Application No: WA/68/20/OUT

Site Address: Land west of Tye Lane Walberton

Description of works: Outline application with all matters reserved, other than means of access, for the construction of up to 155 No. dwellings (30% affordable homes) & amendment to boundary of garden land to serve adjoining property. This application affects the character & appearance of the Walberton Village Conservation Area, may affect the setting of listed buildings & is a Departure from the Development Plan.

Thank you for your internet representation made on 10th November 2020 which has been recorded as an objection with the comments as follows:

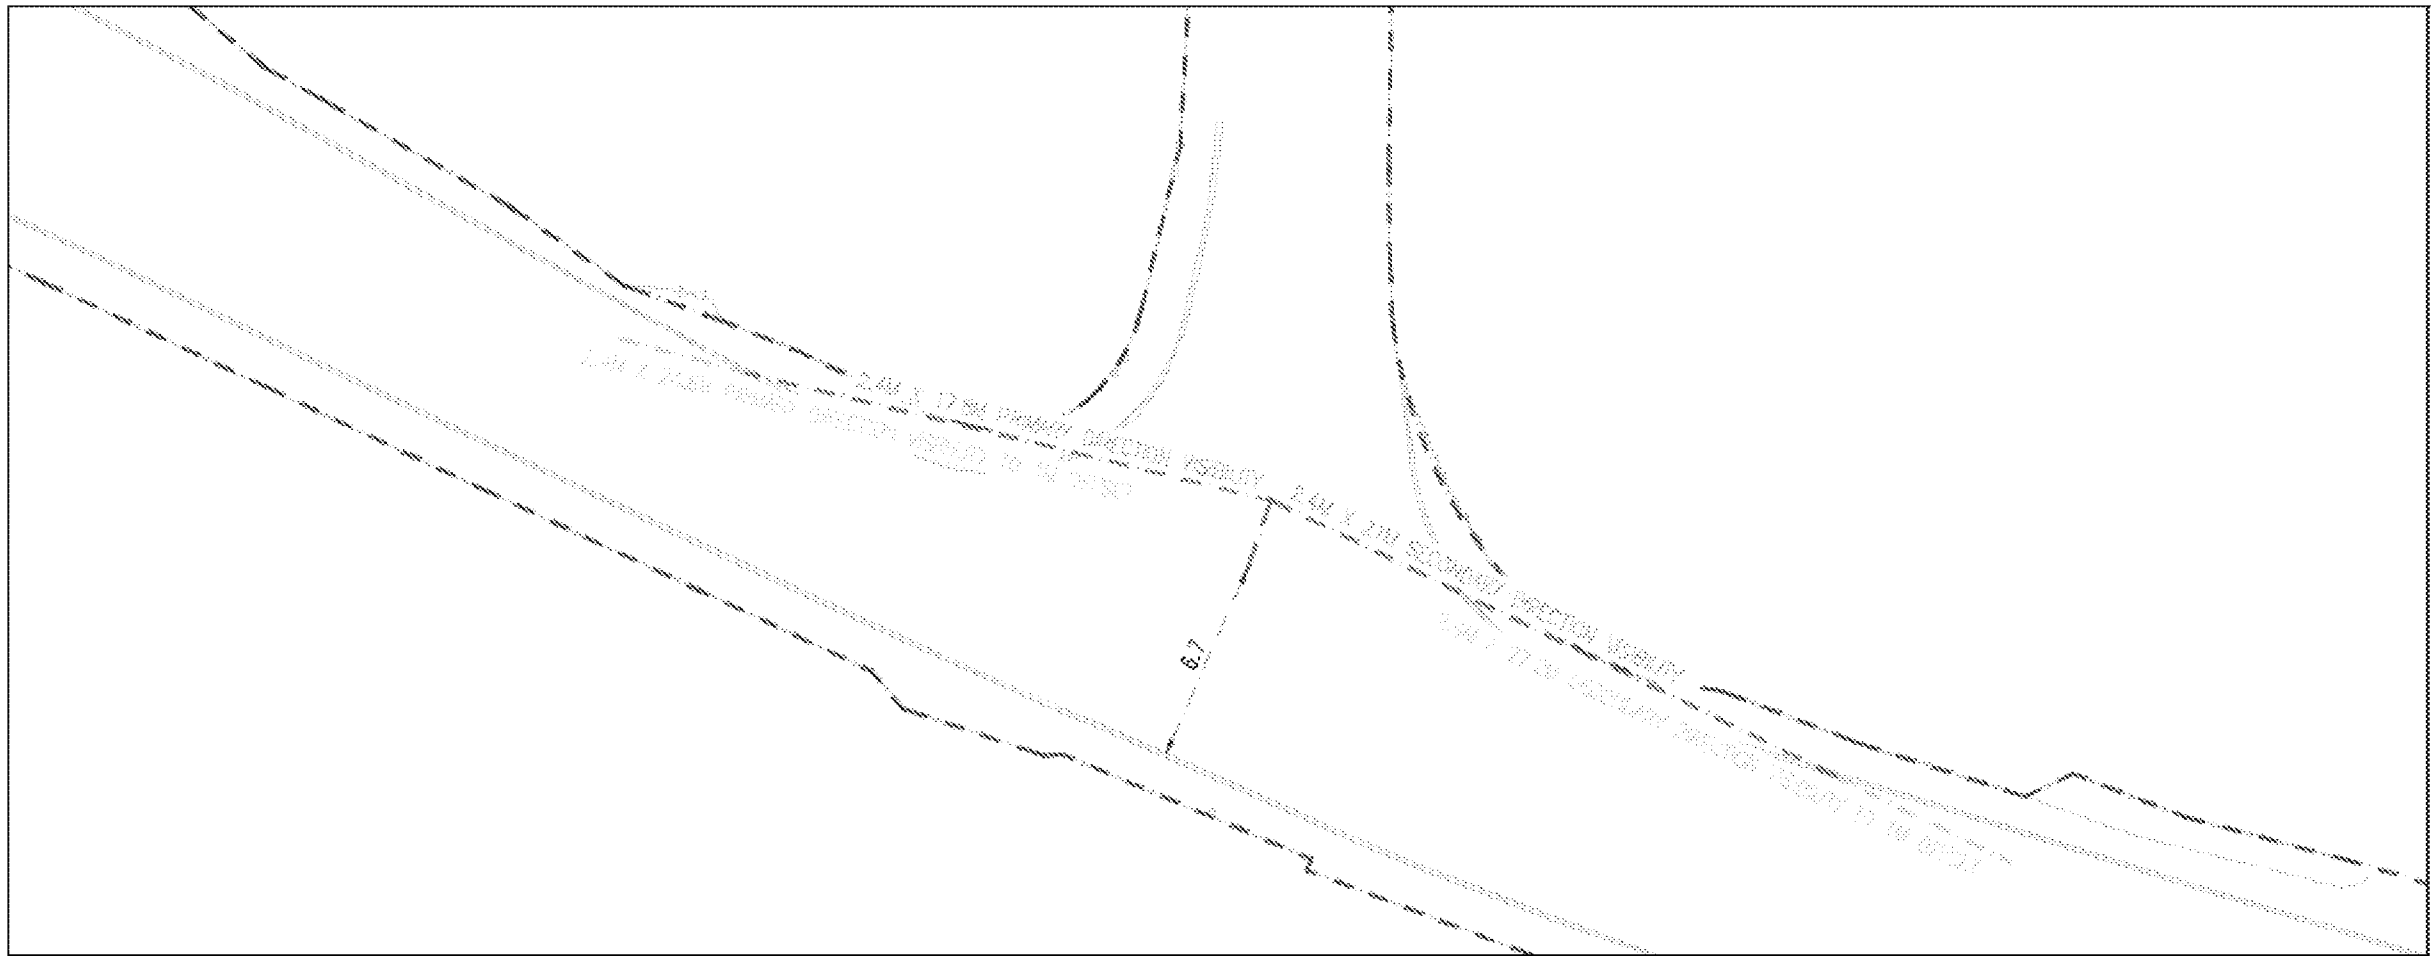
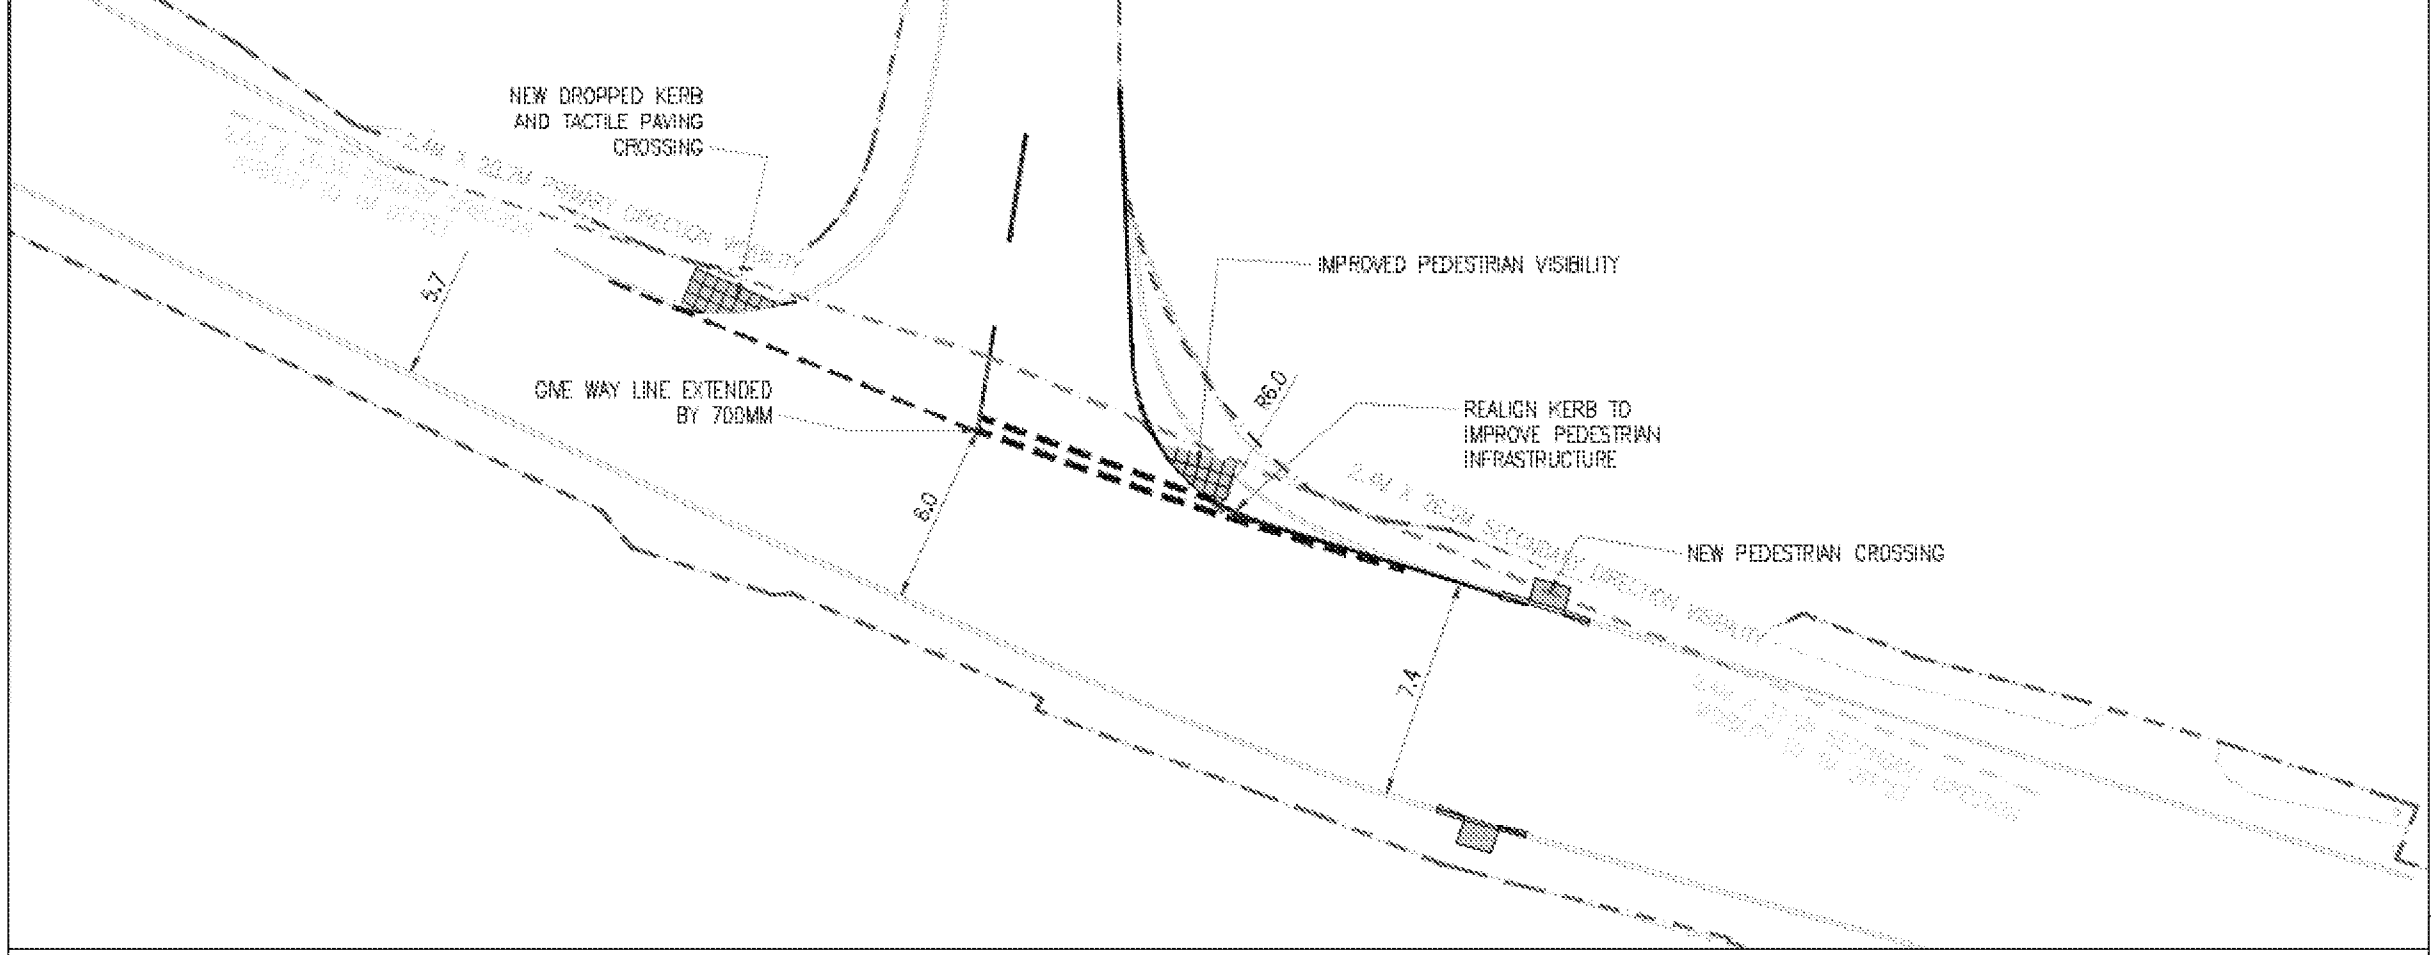
The formation of the proposed residential access in this current application will adversely impact on the rural character of Tye Lane. In addition, the Travel Plan indicates the necessity of ensuring that existing banking and planting will need to be reduced to 600mm in height within the visibility splays but no precise details of the effect of this requirement seems to be included in the application. In the absence of any detailed plans showing what planting will need to be reduced in height and how any banking is to be reconfigured, the Panel must take a view that there may be further detriment to the rural character of Tye Lane.
